CITY OF ALBUQUERQUE

December 19, 2013

**Re: Montecito West Units 1 and 2
Grading and Drainage Plan and Drainage Report
Engineer's Stamp Date 11-07-13 (D09/D004)
Erosion Sediment Control (ESC) Plan
Engineer's Stamp Date 11-07-13 (D09/E004)**

STORM DRAIN INLET PROTECTION
NOT TO SCALE

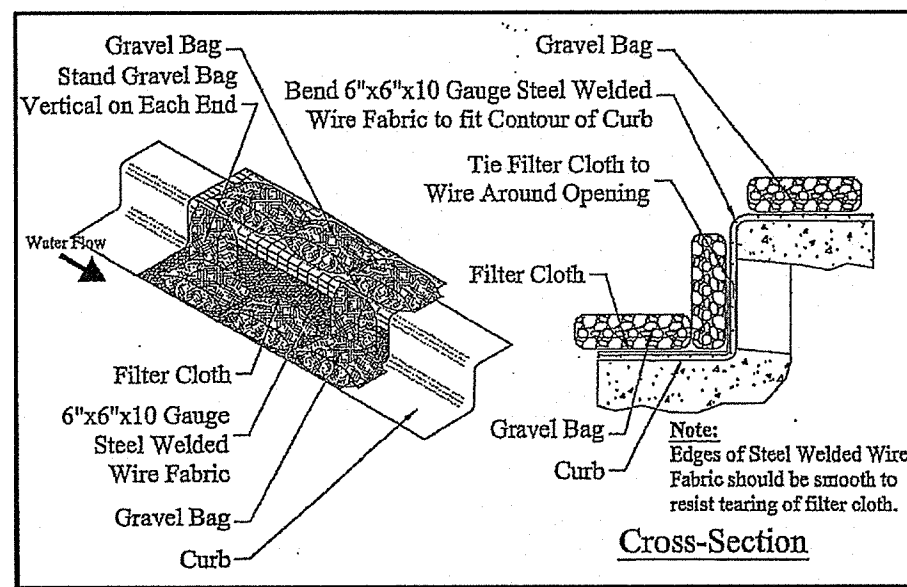
- c) Provide an entrance detail for the construction entrance (with a minimum 50' depth).
 - d) Show the location of the NPDES Posting Board and Staging Area.

MONTECITO WEST UNITS 1 & 2
EROSION CONTROL PLAN

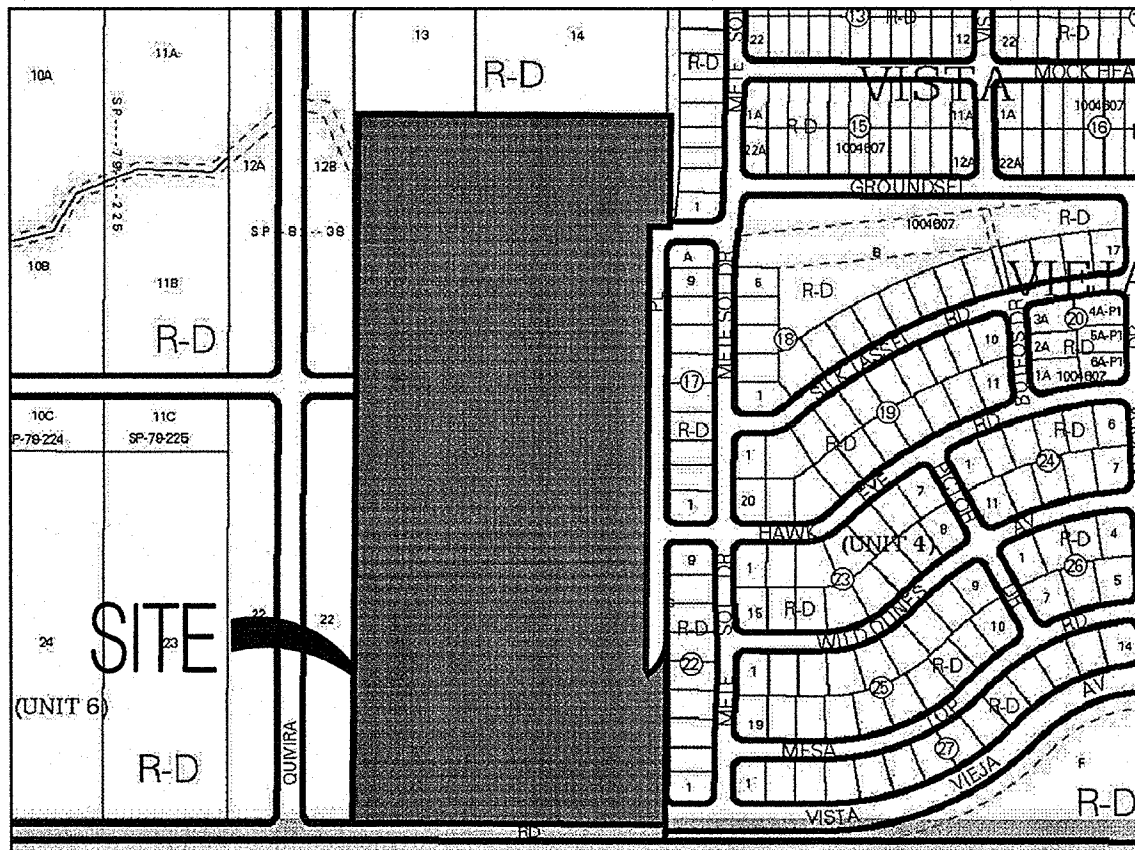
- 14) Relocate the storm drain pipe under the curb and gutter on Espacio Verde Road.
- 15) Stamp and sign all the plans.
- 16) Erosion Sediment Control plan (D04/E009) must be under a separate submittal and submittal form.

- a) All the offsite work should be included.
 - b) Include a note that "No offsite storm drain inlet should be covered. Only onsite/proposed inlets can be covered during construction."

- e) A note to the plan that "Project is required to maintain a regiment of street sweeping and clean up measures in the event of track out to minimize and prevent off site conveyances during construction."
